Our Case Number: ABP-316272-23

Re: Bus Connects Templeogue/Rathfarnham to City Centre Core Bus Corridor Scheme
Templeogue/Rathfarnham to City Centre

Re: Bus Connects. Submission re proposed Templeogue / Rathfarnham to City Centre Core Bus Corridor Scheme

Drawing File Name: BCIDC-ARP-GEO_GA-1012_XX_00-DR-CR-0005

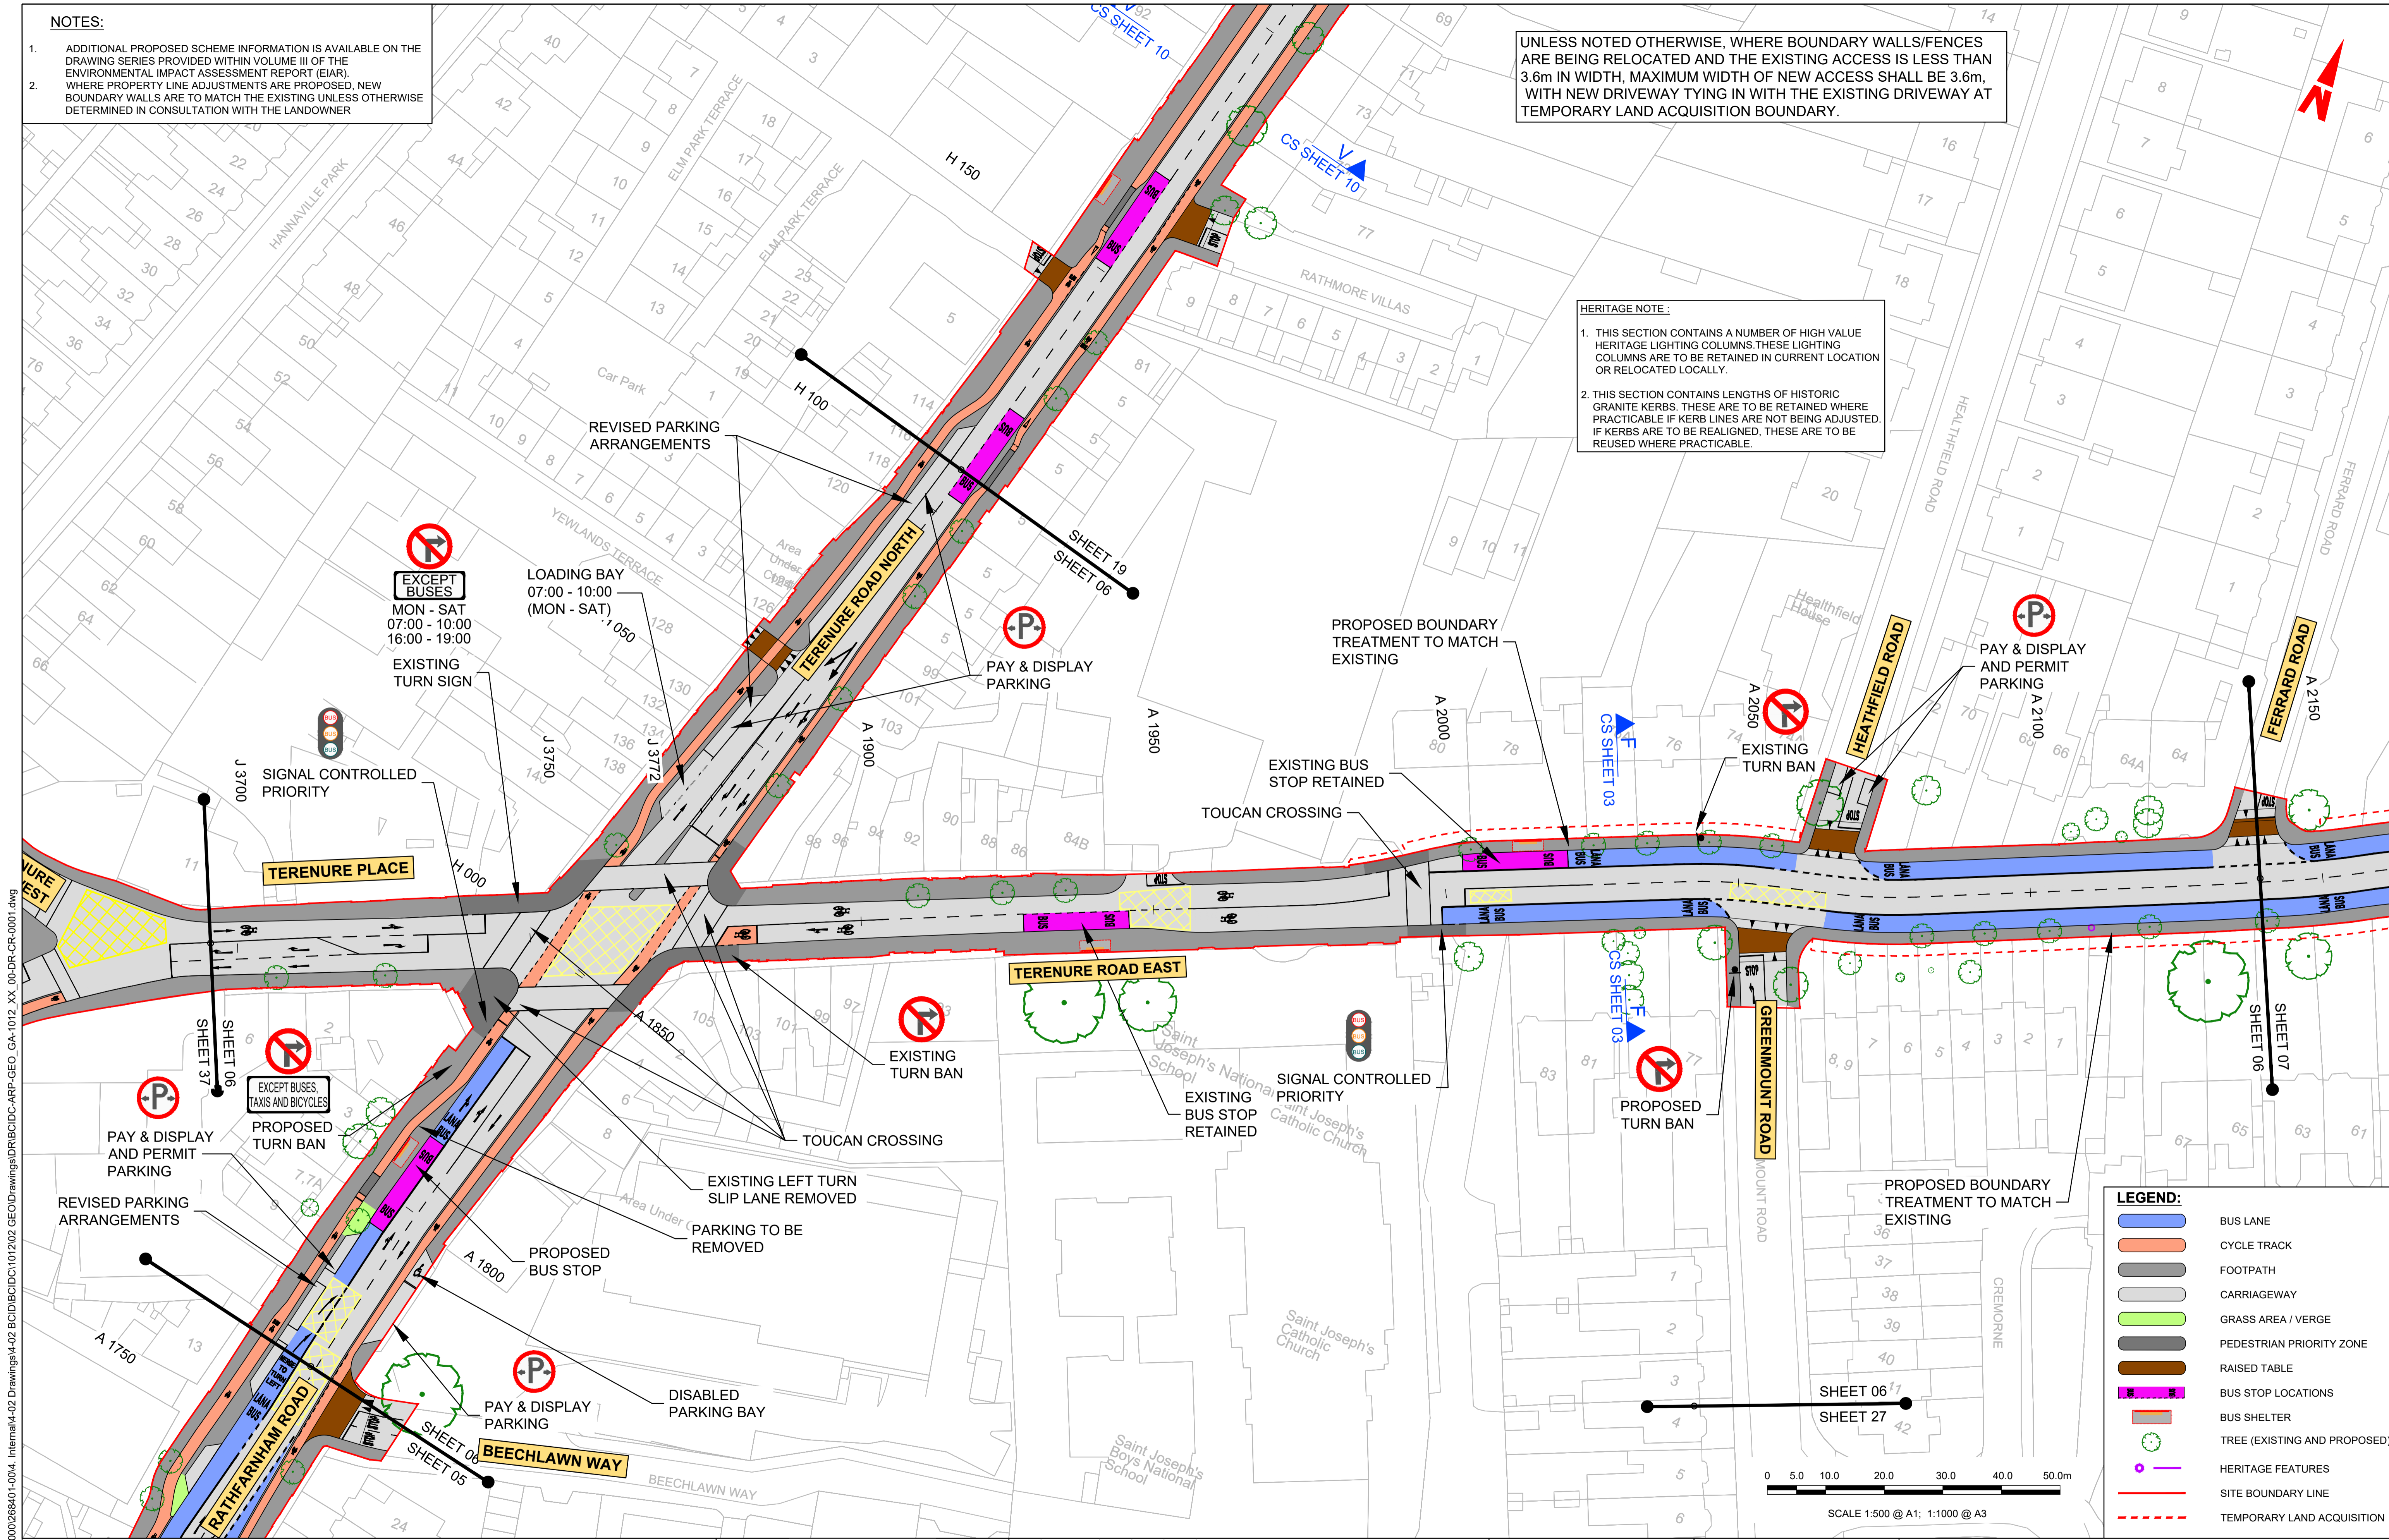
The junction at Rathdown Park/Rathfarnham Rd is already a problem. It can take a long time to get through the (short) green light when exiting from Rathdown Park. The situation will get considerably worse if a significant amount of extra traffic is funnelled there. That extra traffic is essentially being diverted away from the Templeogue bus corridor at the expense of the Rathfarnham bus corridor. In this regard it is important to note that the Rathfarnham bus corridor will share one lane with cars for a section before and after that junction - see General Arrangement Drawings 8 & 9 of 47².

Suggestion: move the bus gate from Olney further away from Terenure village. The existing bus stop at the ETB Sports Ground might be a better location for the gate. That would have the effect of reducing the number of cars at the Rathdown Park/Rathfarnham Rd junction and on the Rathfarnham bus corridor because:

- (i) it will stop cars from beyond Terenure College using Olney as a turning point and then entering Rathdown Park and
- (ii) it would allow residents between the village and the bus gate (to include Olney) who need to use their cars to travel to Terenure village and beyond (which is only a small number) to continue to go through the village via Templeogue Rd.

Secondary submission – if the bus gate location is not changed, the hours of operation (and the related left turn ban from Olney) should be limited to peak times. The proposal to operate the bus gate from 6am to 8pm, 7 days a week is excessive and disproportionate.
